Our ref: DOC20/34072

Inland Rail Narrabri to North Star – Submissions Preferred Infrastructure Report

Thank you for your email dated 9 December 2019 to the Biodiversity and Conservation Division (BCD) of the Department of Planning, Industry and Environment inviting comments on the Submissions Preferred Infrastructure Report (SPIR) for the Inland Rail Narrabri to North Star (N2NS) project.

Figure 5
 Revised Development Footprint

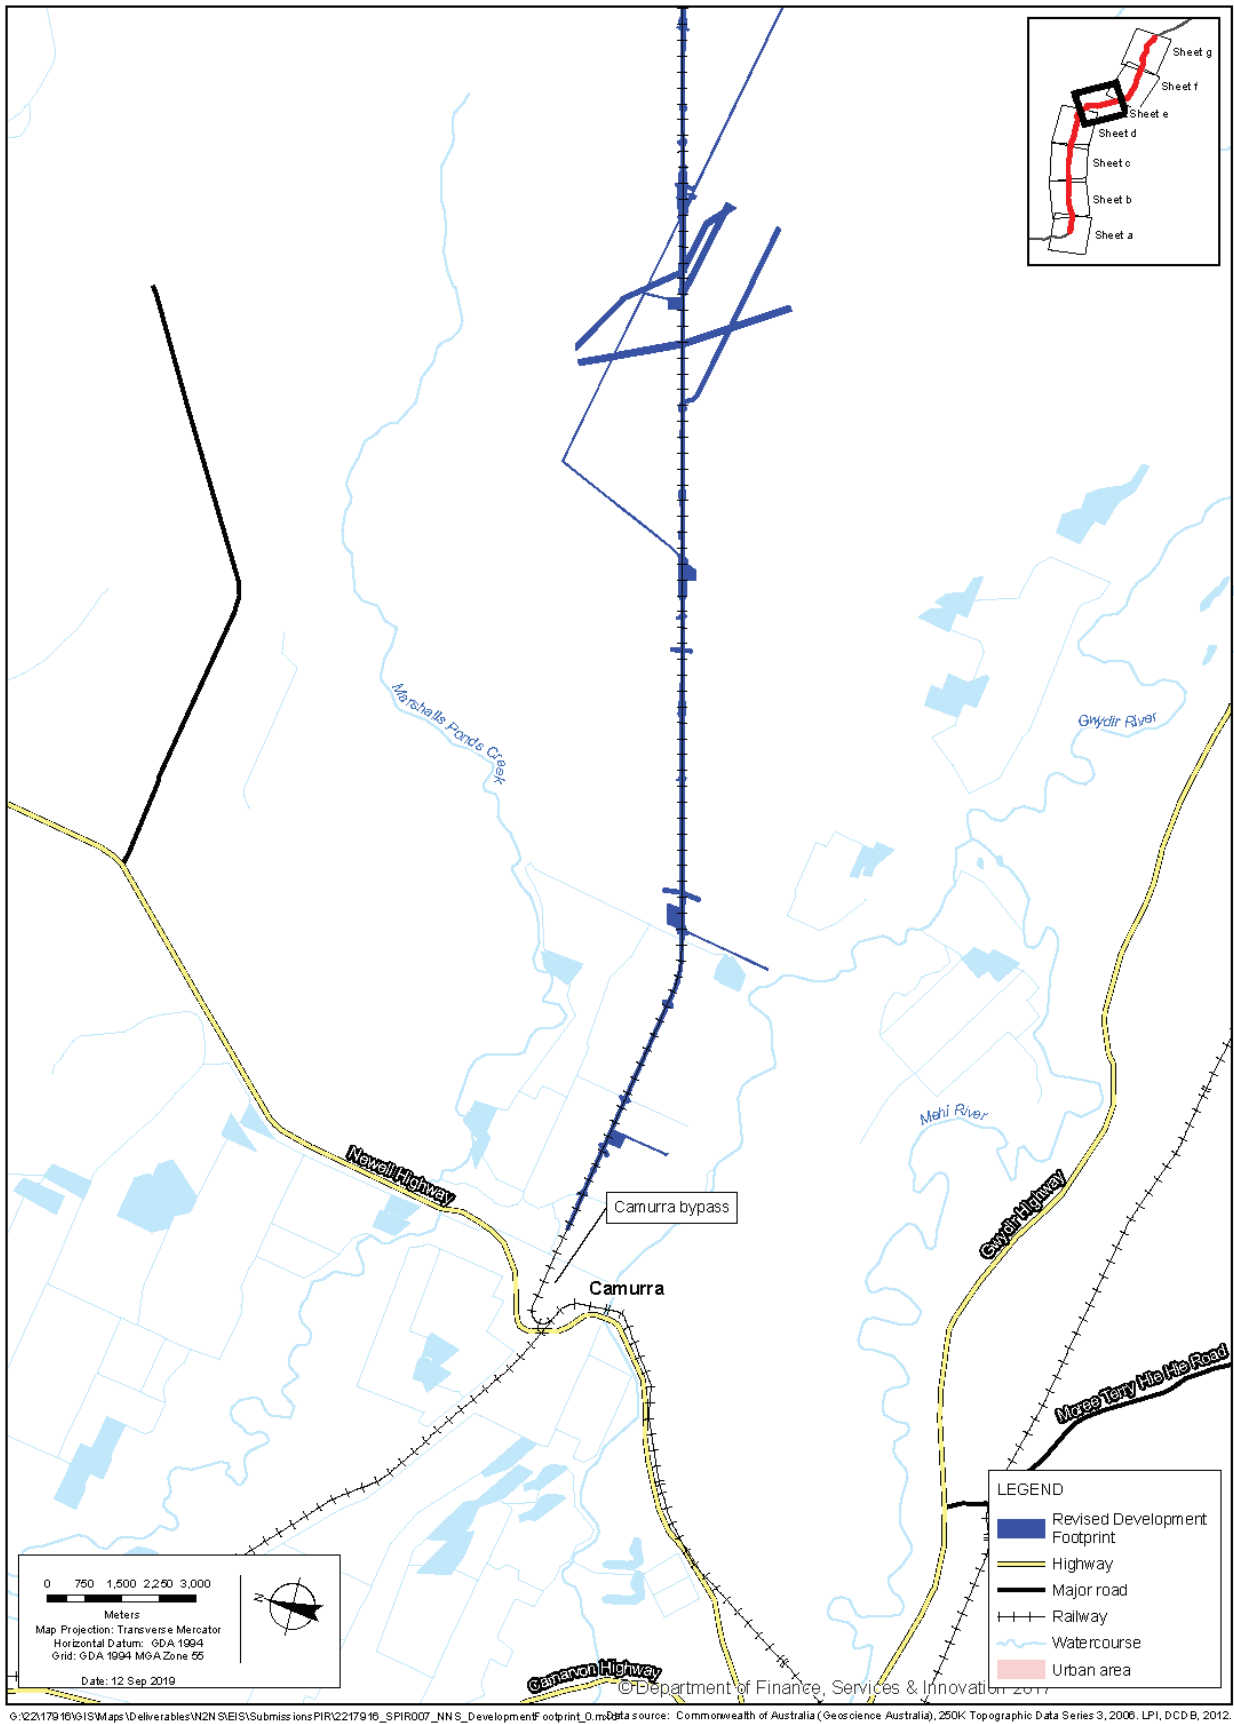
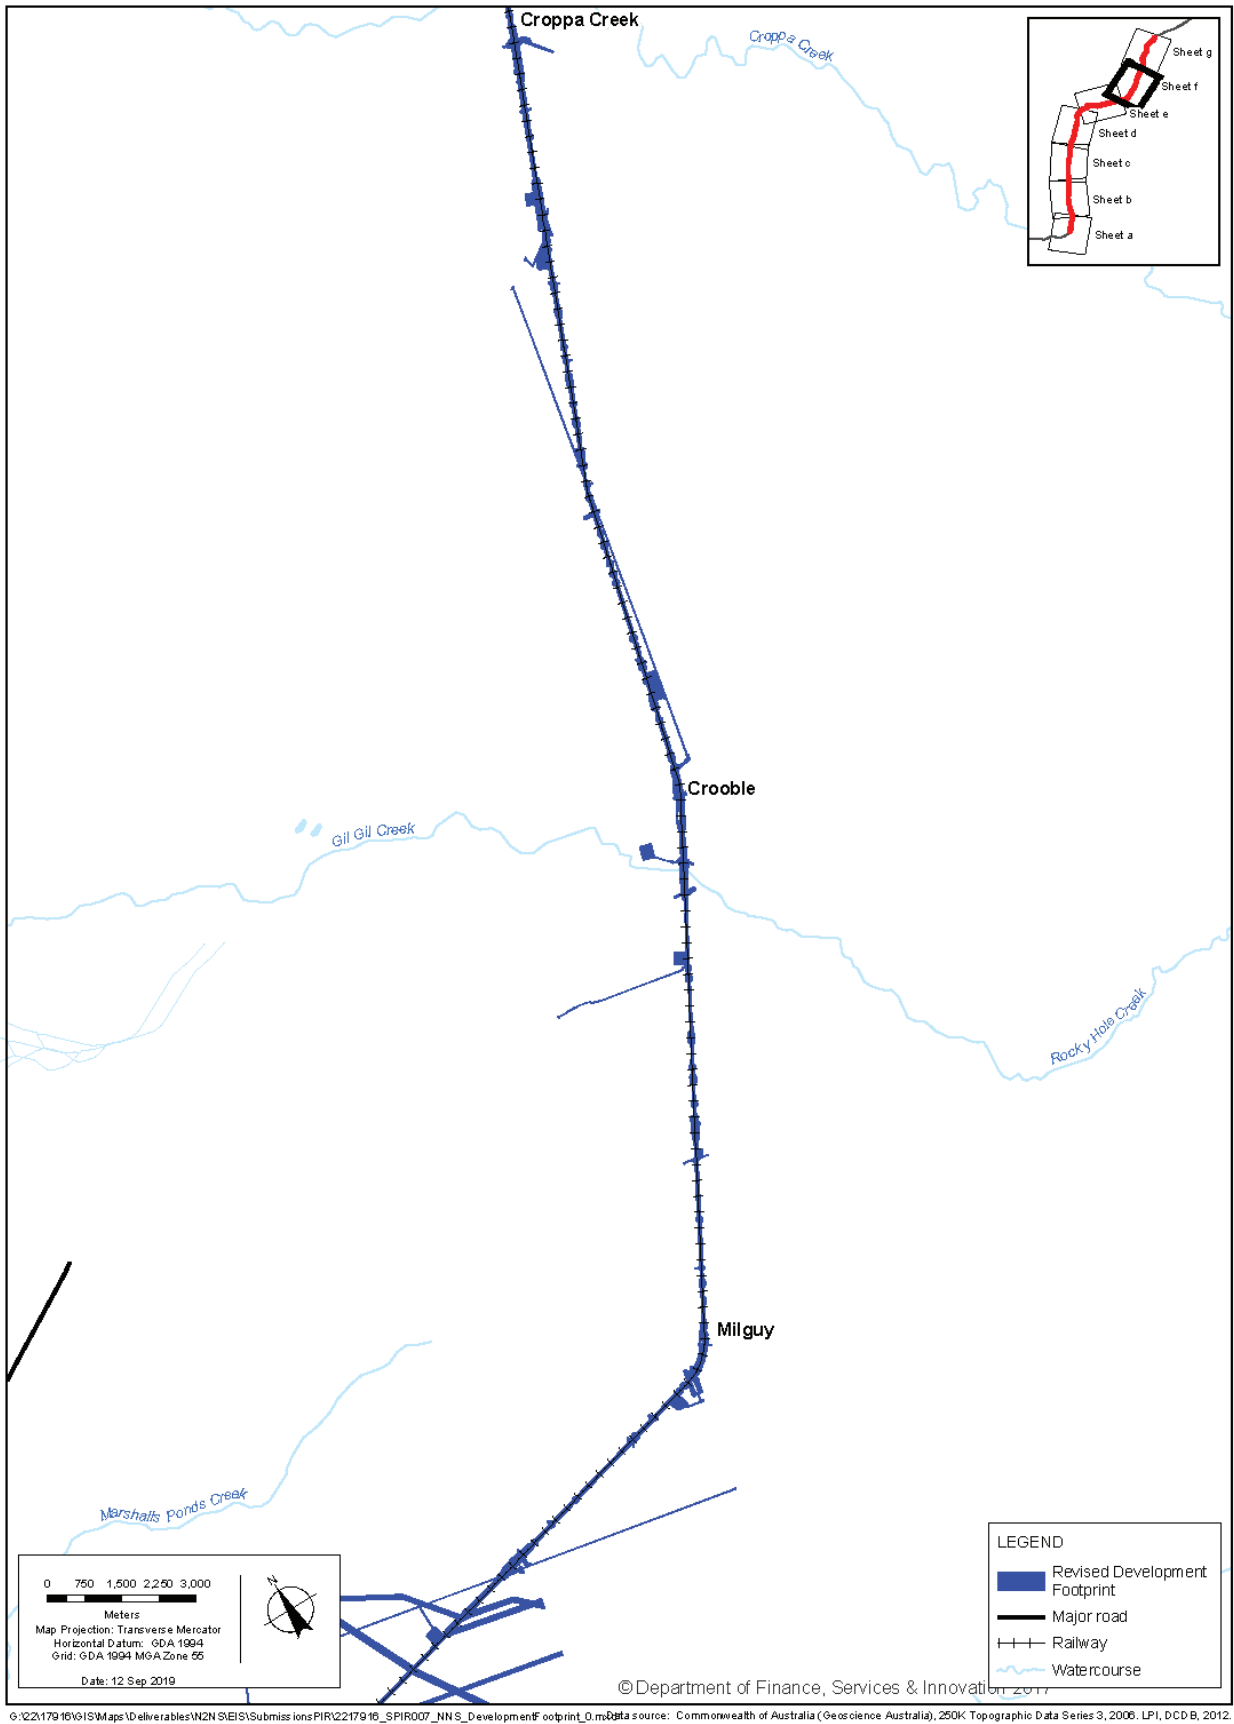
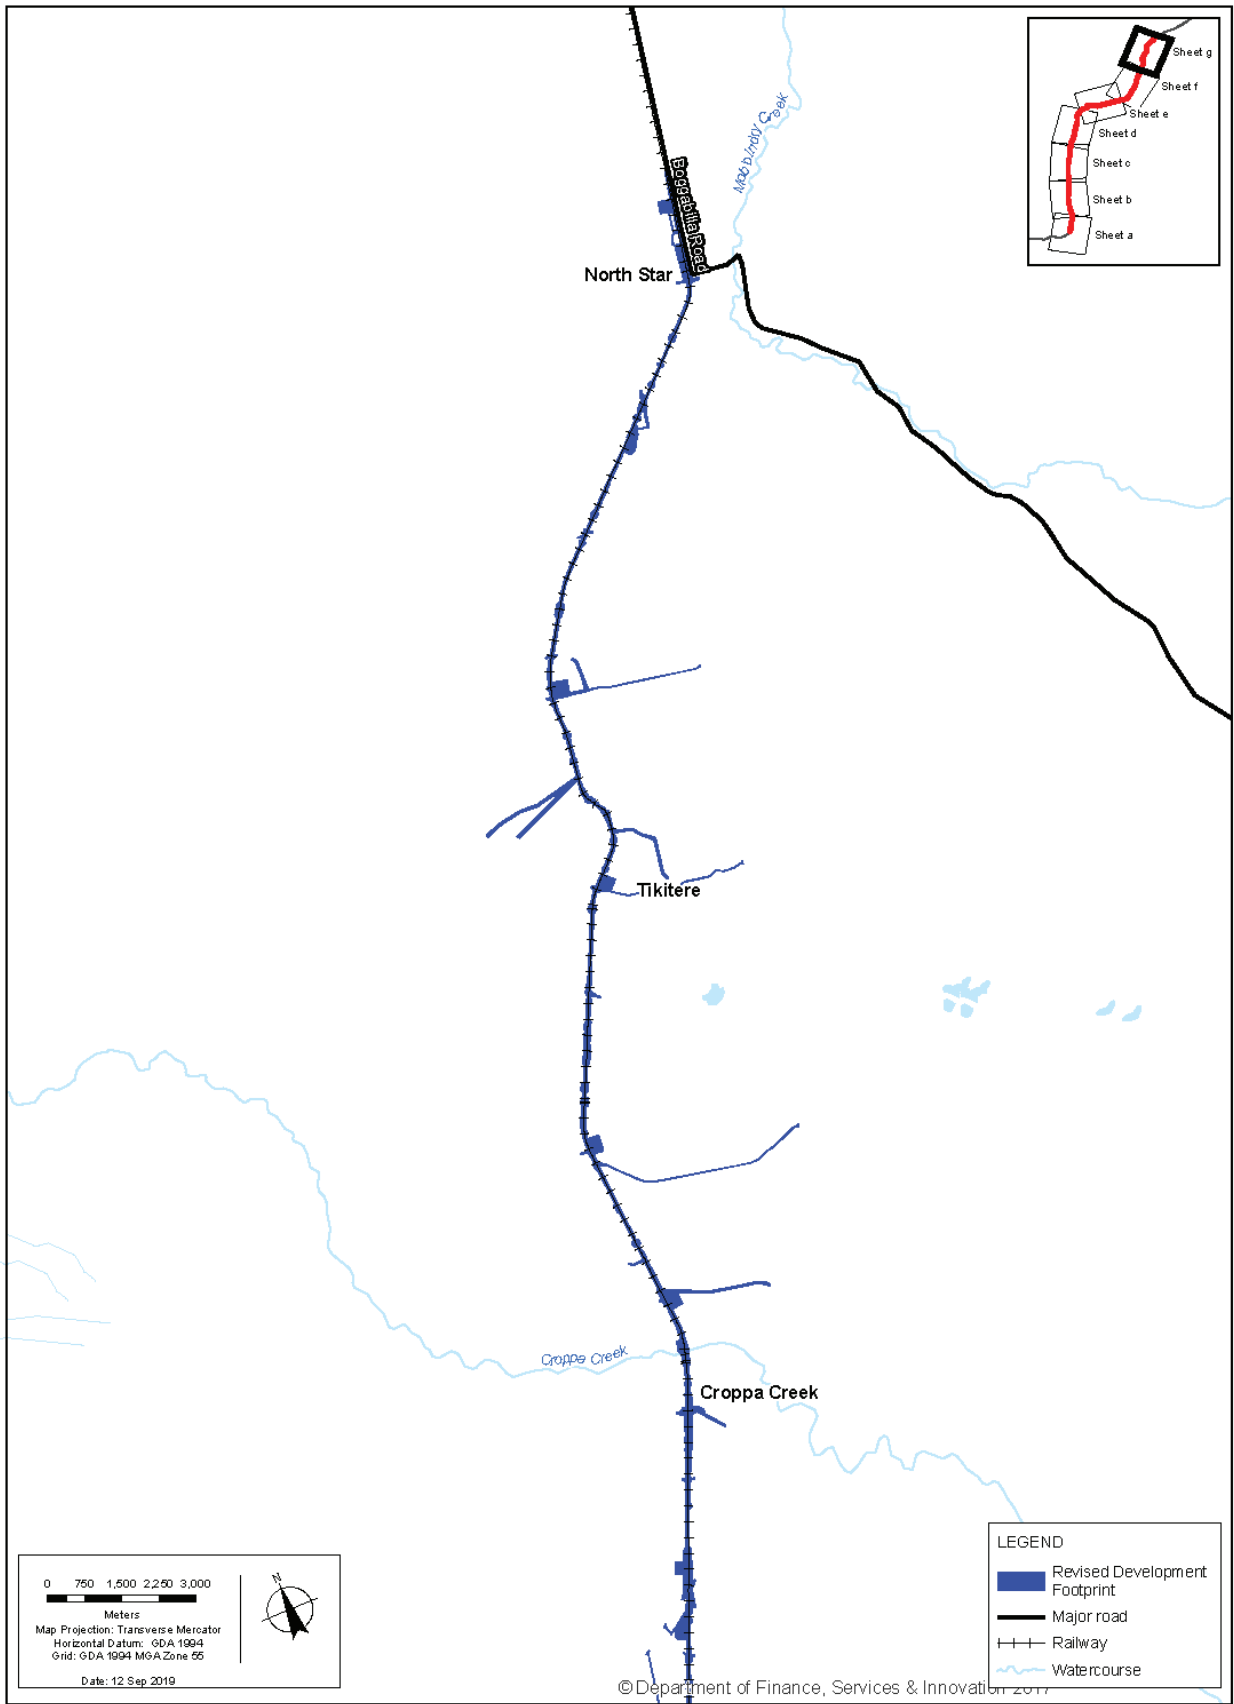
The increased impact to PCTs is detailed in Table 3 and illustrated in Figures 1-7. However, the figures are not displayed at a scale that clearly shows the amended footprint, and they do not illustrate the PCTs being impacted upon. BCD is unable to provide feedback on the validity of the amended impacts to native vegetation without access to this information.

Develop an updated vegetation map, produced at a scale where individual PCTs are easily identified.

Provide BCD with updated spatial files, including the amended footprint, updated vegetation map, and location of rapid assessment plots.
